September 1, 2022

Re: 8619 36th Avenue NE – Heart Saved Enhanced Services Facility (PA22-036)

Thank you for your project submittal. Upon first review of the above-referenced project, the Planning Division has the following comments/requirements. Planning Comments 1-4 shall be addressed prior to a SEPA determination or preliminary site plan approval being granted.

RE: Heart Saved Enhanced Services Facility, File# PA22-036
2 Story, 12,000sf building with retail/commercial on 1st floor and 16 bed enhanced services facility on the 2nd floor.
8619 36th Ave NE & Parcel # 004560000202

36TH AVE. NE
N.T.S.

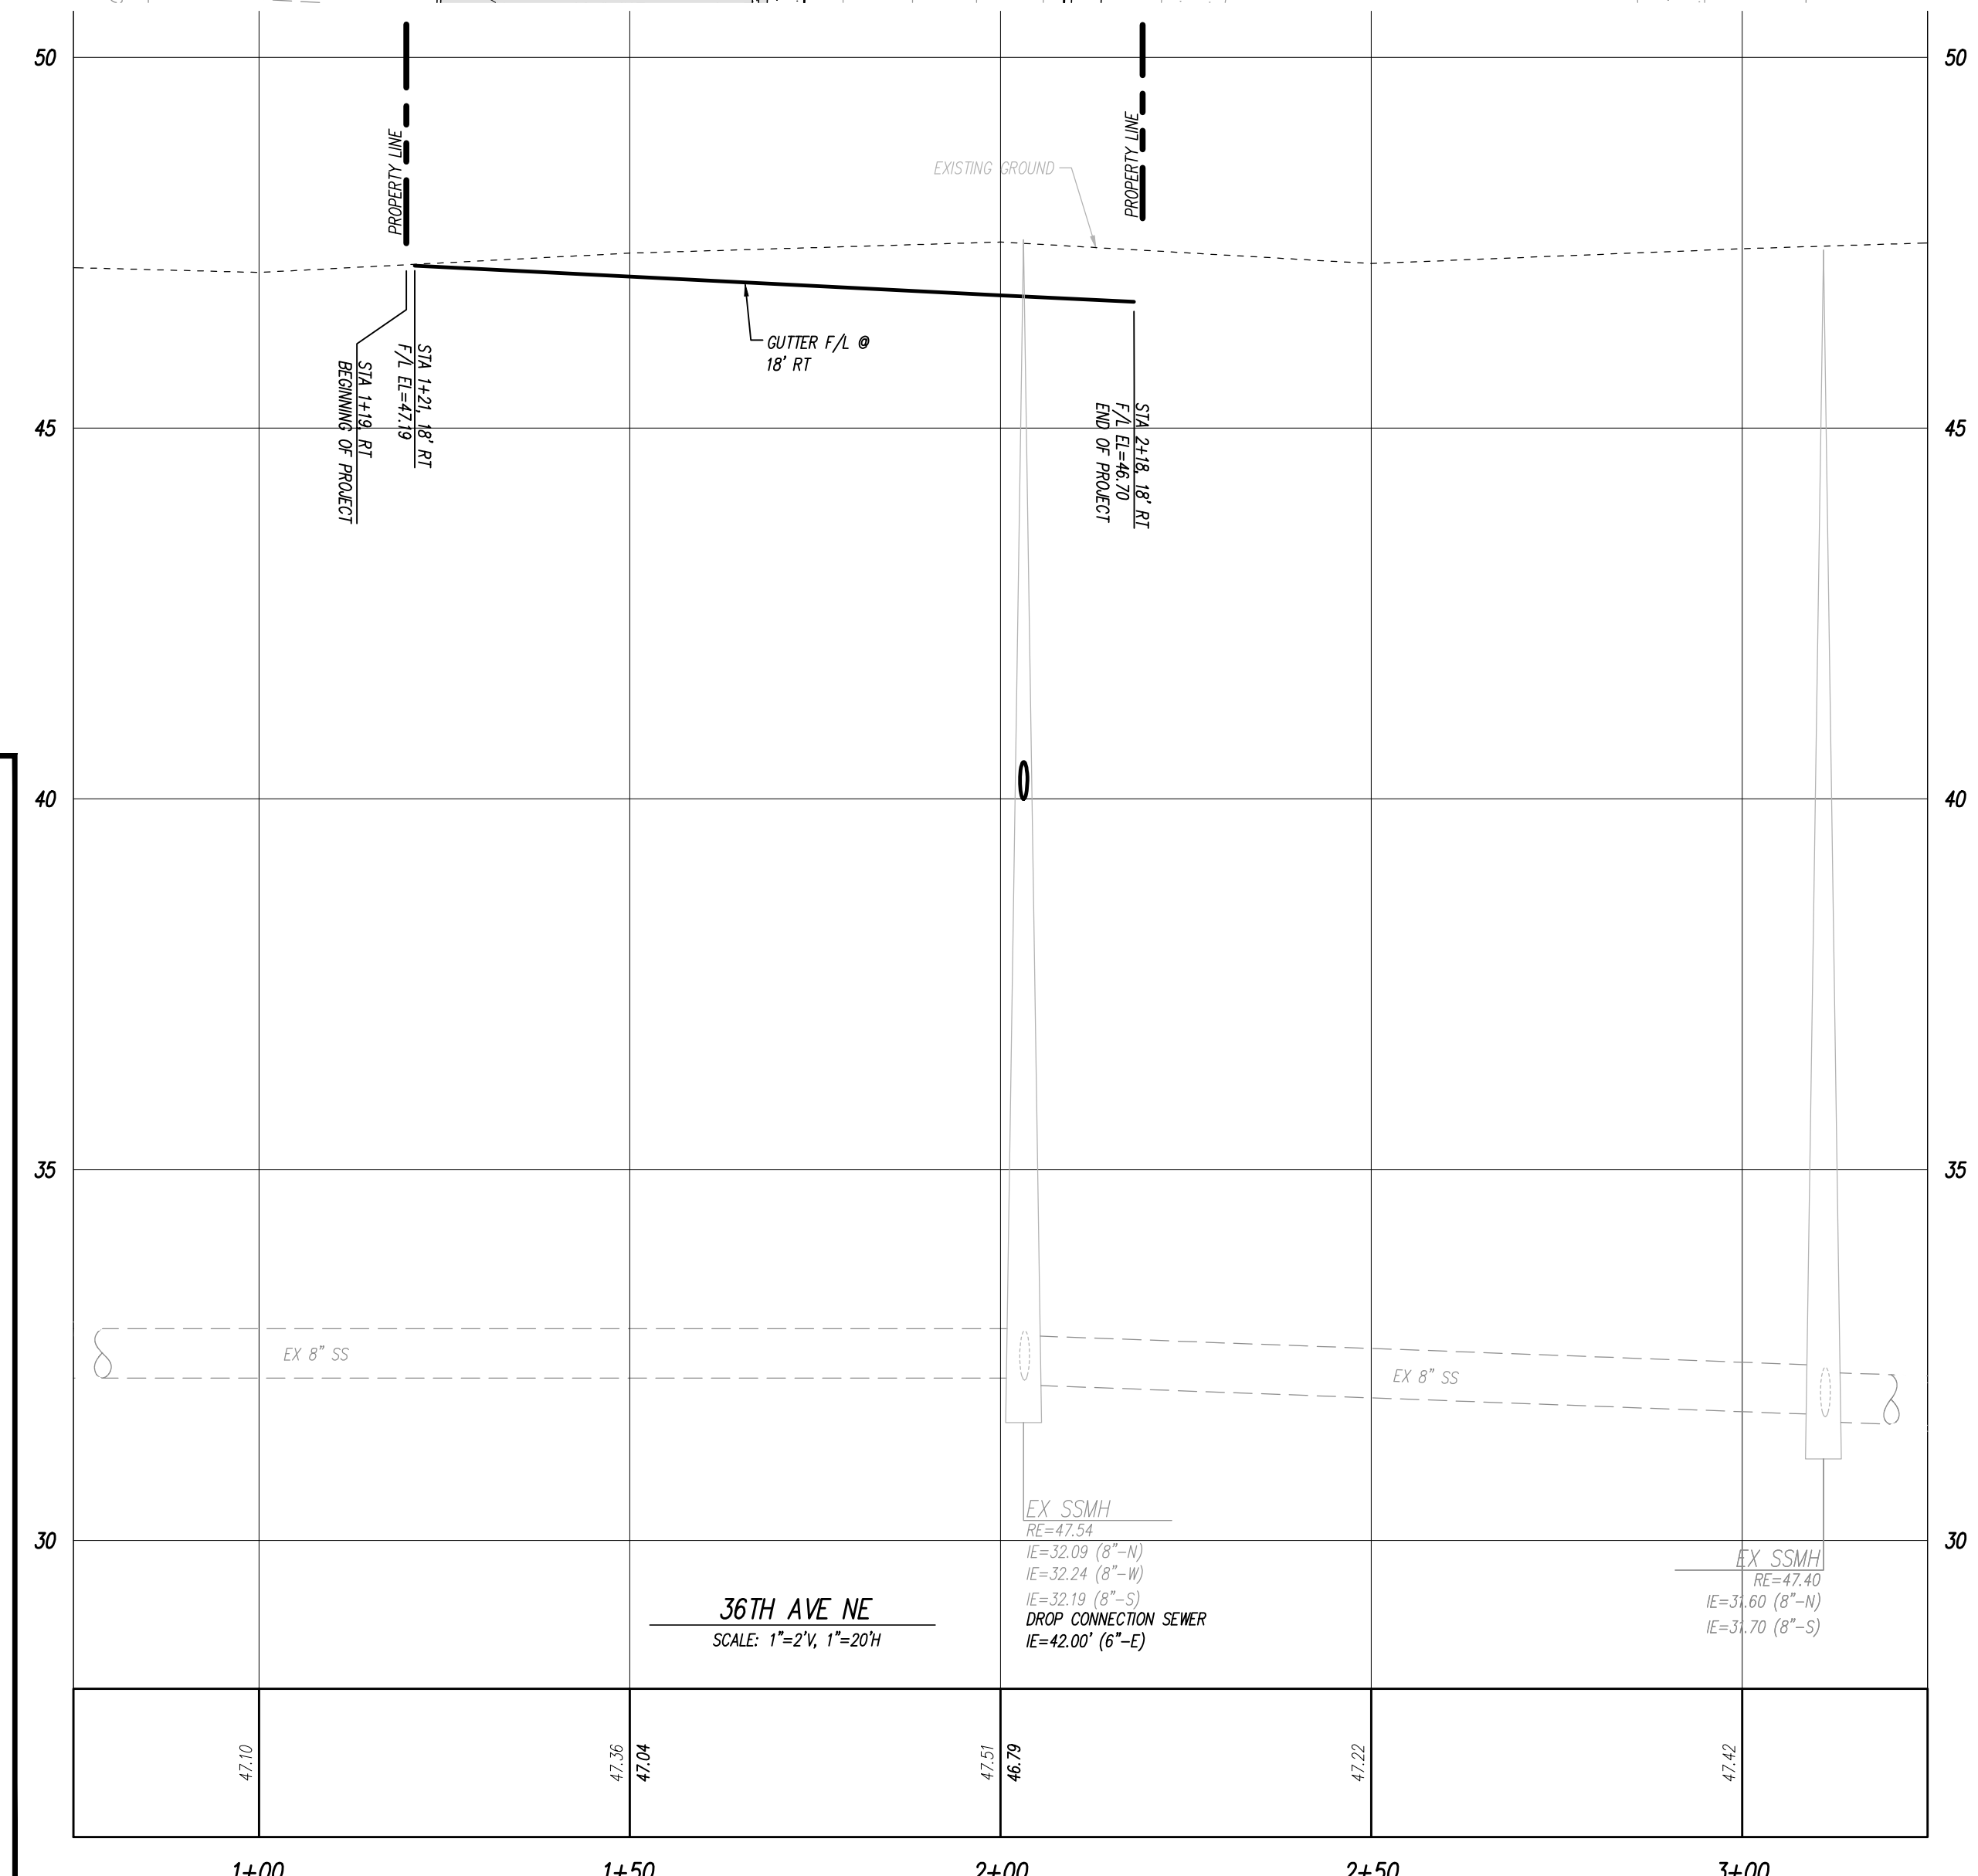
- a. 37th Ave NE is classified as a three lane arterial and is to be built compliant with SP 3-201-003 of the EDDS.

- a. TIA is acceptable.
- 3) 36th Ave NE Frontage improvements:
 - a. Roadway frontage improvements shall be per EDDS Standard Plan 3-201-003 for a three lane Collector Arterial including curb/gutter, sidewalk, landscape strip and street lighting within 60' ROW.
